Our Ref: F2016/00481 – D02796544
Contact Officer: Elias Coorey

14 November 2016

**STATE SIGNIFICANT DEVELOPMENT APPLICATION: UNSW SCIENCE AND
ENGINEERING BUILDING (SEB) (SSD 7518)**

NORTH STREETScape ELEVATION
 2001-SSD SCALE: 1:200

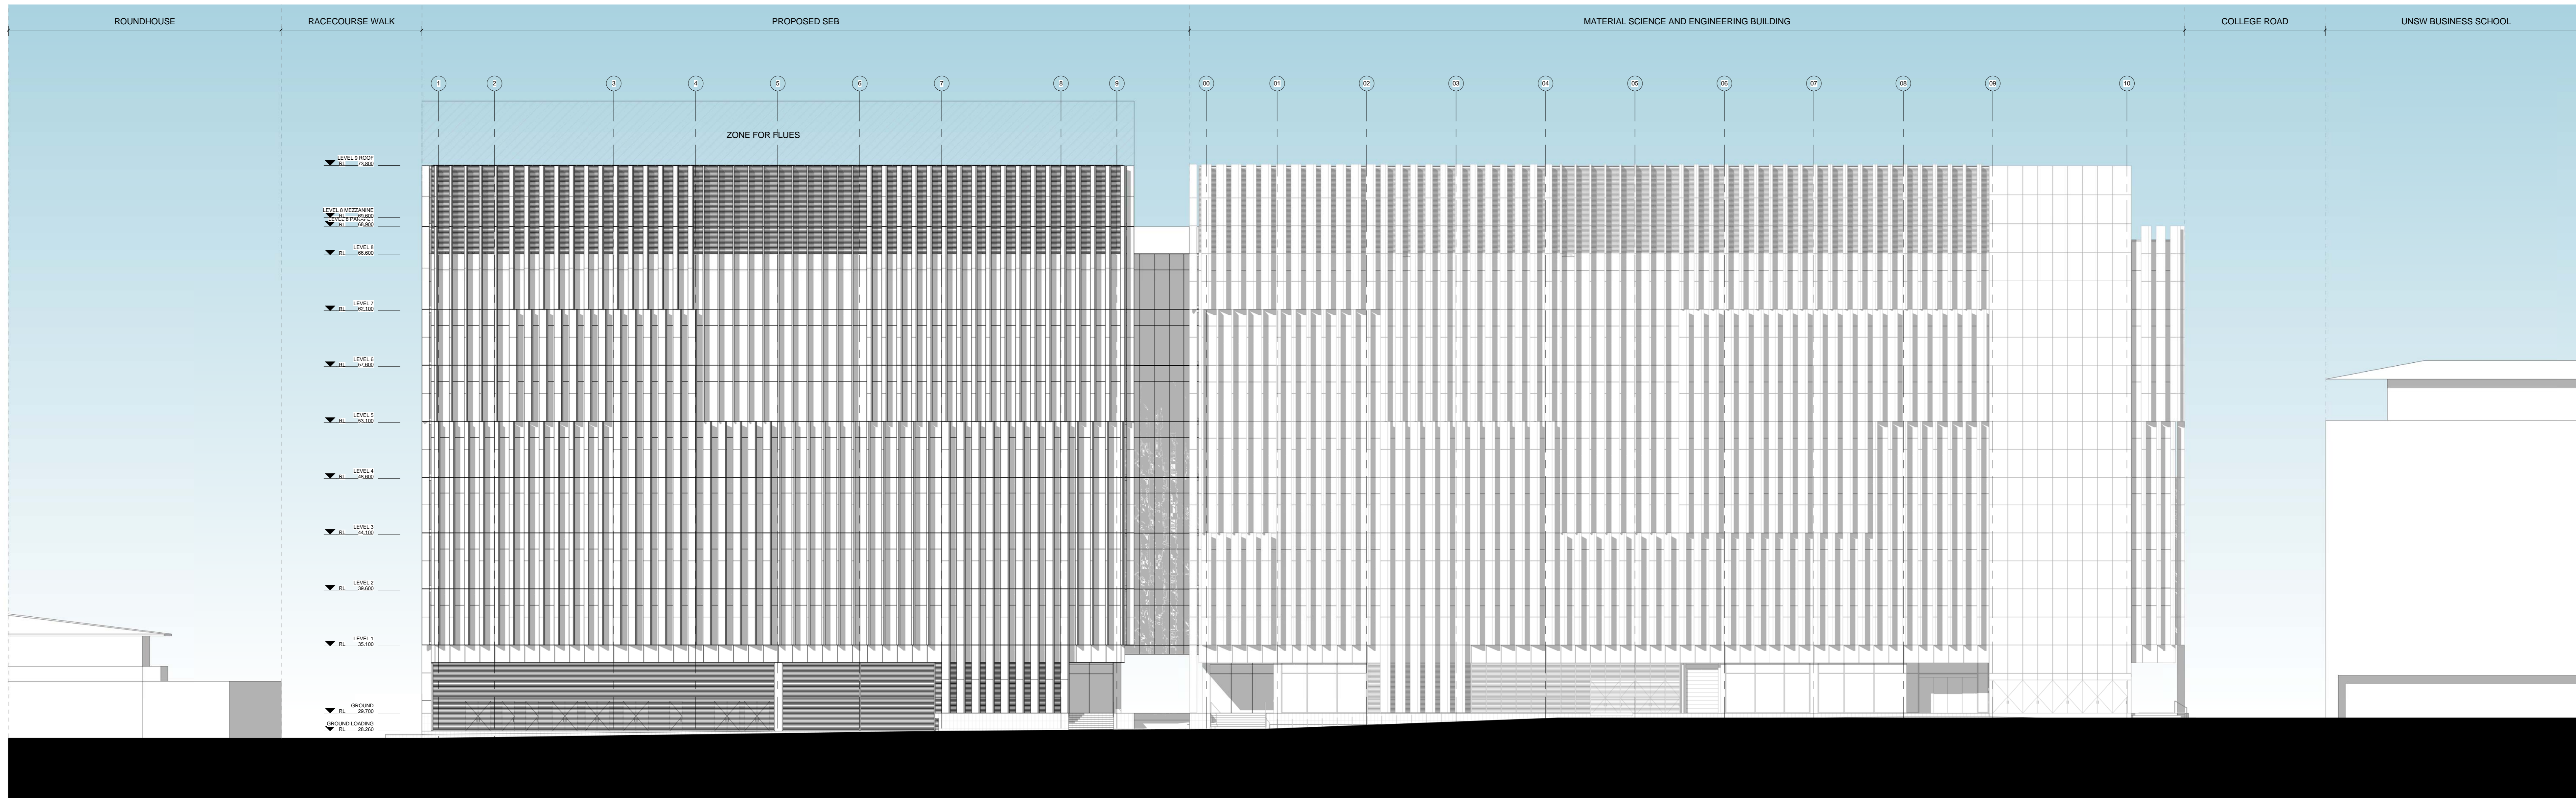
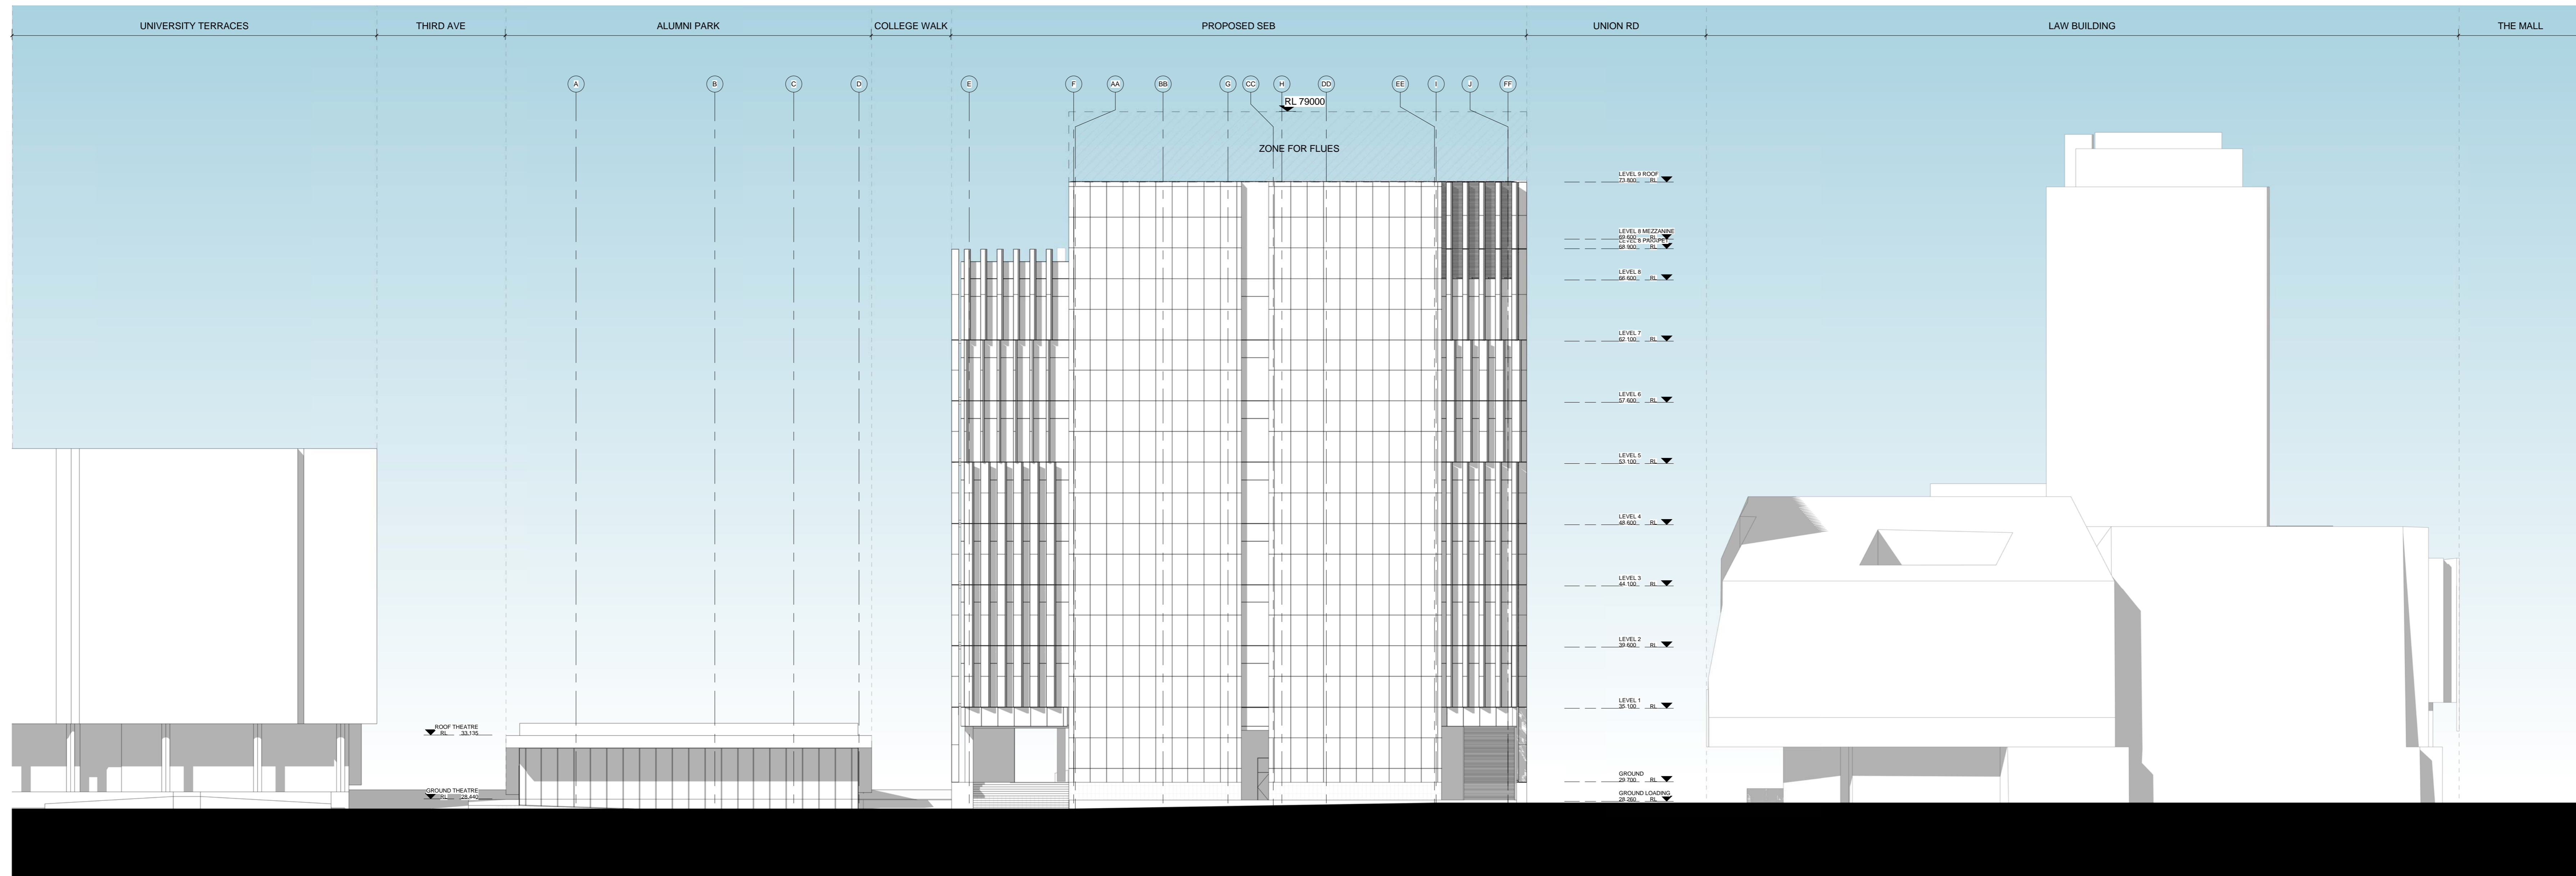
The proposal incorporates a building parapet height of approximately 40.64m (RL68.90 – RL28.26), top of flue height to 45.54m (RL73.80 – RL28.26) and above the 24m height limited established in figure 5.8 of the RLEP 2012.

The overall height of the Science and Engineering Building (SEB) is consistent with the size of the Material Sciences and Engineering Building (MSEB); the proposal adopts a similar vertical louvres design providing a consistent theme across both the SEB and MSEB. The combined length of the MSEB and SEB is significant and is relieved by projecting the SEB built form northward further than the MSEB over College Road. This encroachment over College Road is inconsistent with the building alignment control shown in Figure 5.7 in Part E2 of the RDCP 2013. Whilst the encroachment provides some relief to the combined length of both buildings, this is however only necessitated only by the significant bulk and scale of the development and connecting bridge over 7 levels. It is considered that relief of the considerable length of the combined buildings could be achieved by alternative methods of design and articulation and a reduction of building depth of the SEB is required. A reduction in building depth of SEB encroaching over College Road would permit a simpler transition of built form down to the smaller buildings further west of the site such as the Roundhouse. A reduction in depth would also maintain openness along College Road assisting its legibility as a pedestrian link and improving crime prevention. Such a reduction would also mean less overshadowing to the buildings located west of the site.
